DRB Application No.: 03-01038 (SBP)
Project Name: PEREA ADDITION
Agent: Consensus Planning

To: Sheran Matson, DRB Chair
From: Mary Piscitelli, EPC Staff Planner
Subject: *Project # 1002563, Case # 03DRB-01038*

This memo will act as comments to the above-mentioned matter. This case was heard at the May 15, 2003 EPC public hearing. This case before the DRB is the final sign off for the site development plan for building permit.

Re: Project # 1002563/ Bed & Breakfast

Site Plan for Building Permit
1211 ROMA AVENUE NW

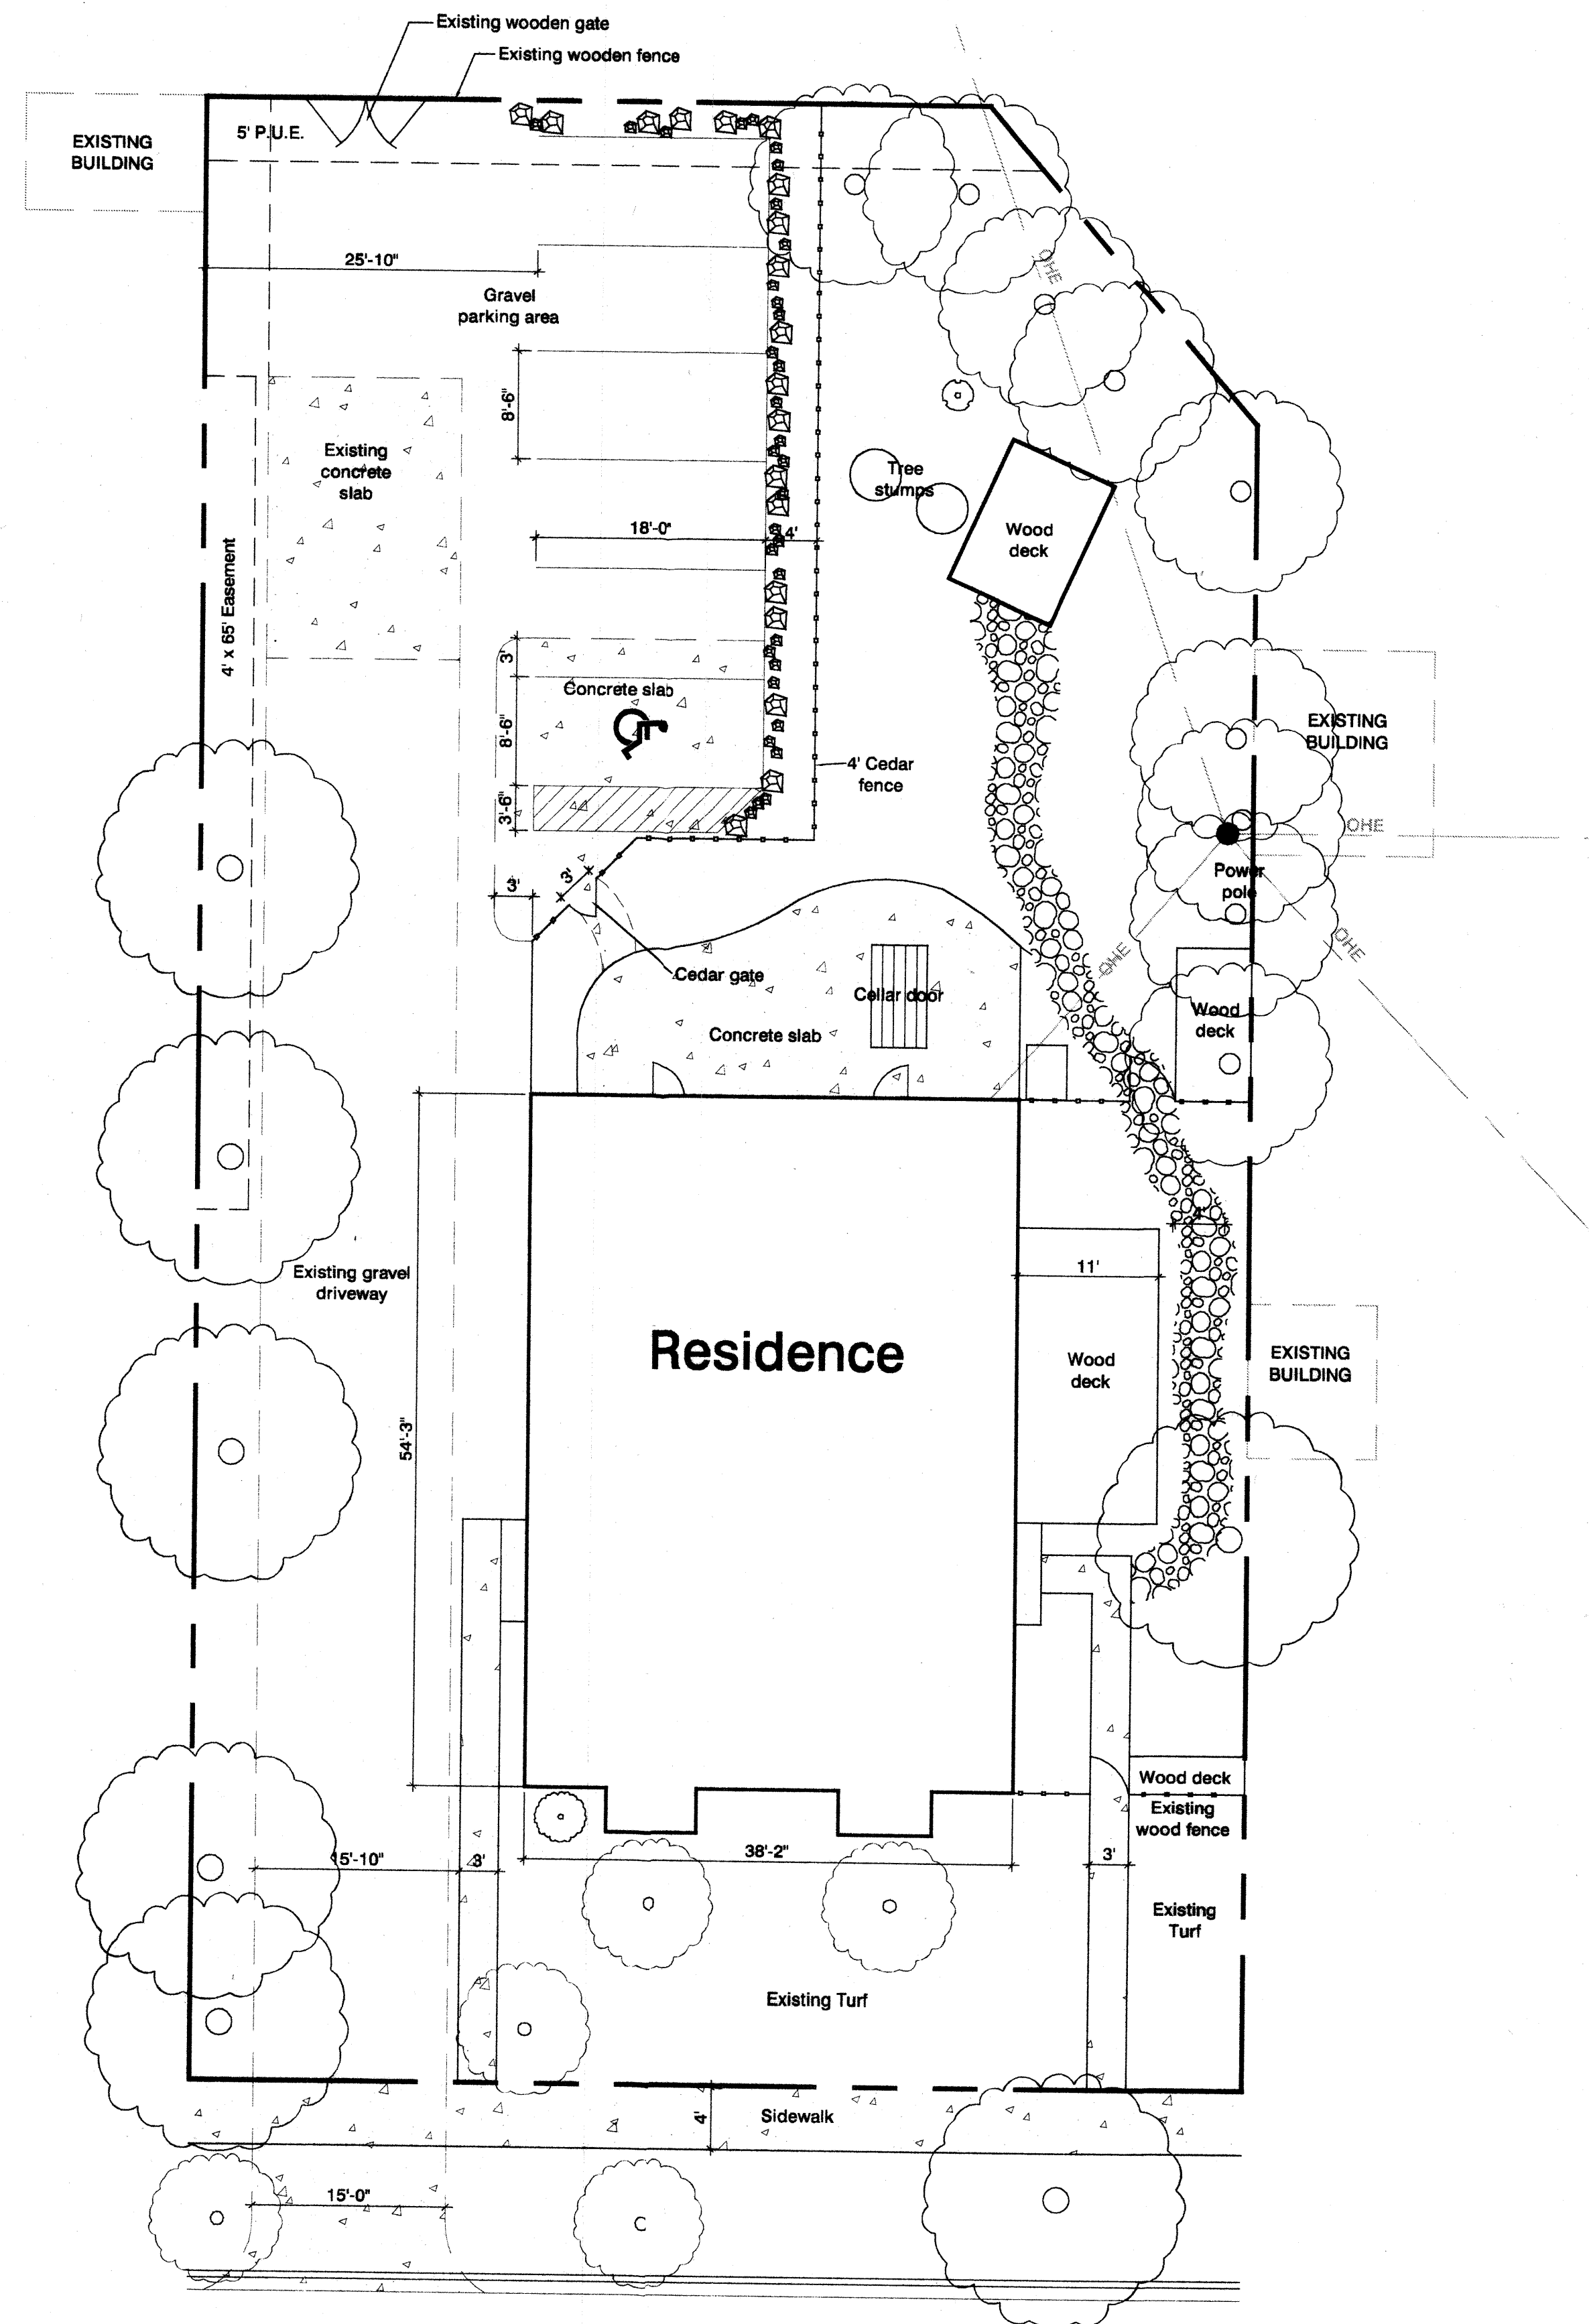
Although no replat is necessary, the Albuquerque geographic information system map should be corrected. Staff recommends that the agent contact the Albuquerque Geographic Information Manager and correct the mapping so that there are no further questions about this issue.

The EPC required site lighting located to illuminate the driveway and parking area while not adversely impacting neighboring historic properties. The EPC required that motion sensor lights be installed to mitigate any adverse impact on the neighboring historic properties. The residential standard porch lights, as noted by the agent, might not illuminate the parking area or driveway sufficiently. Staff recommends that motion sensor illuminating bollards, landscape lighting or other low-height lighting units, rather than the typical shoebox-type design lanterns mounted on 16-foot poles, be installed so that adequate lighting for resident and guest safety is provided. Zoning Code Services should review the site lighting plan for compliance to code requirements for area lighting. This condition should be satisfied prior to the property's use as a bed and breakfast establishment.

2. Research indicates that the property boundary shown on the site plan is correct. No replat is necessary.

3. No additional lighting is proposed for the site other than the existing standard residential porch lights. A note has been added to the site plan.
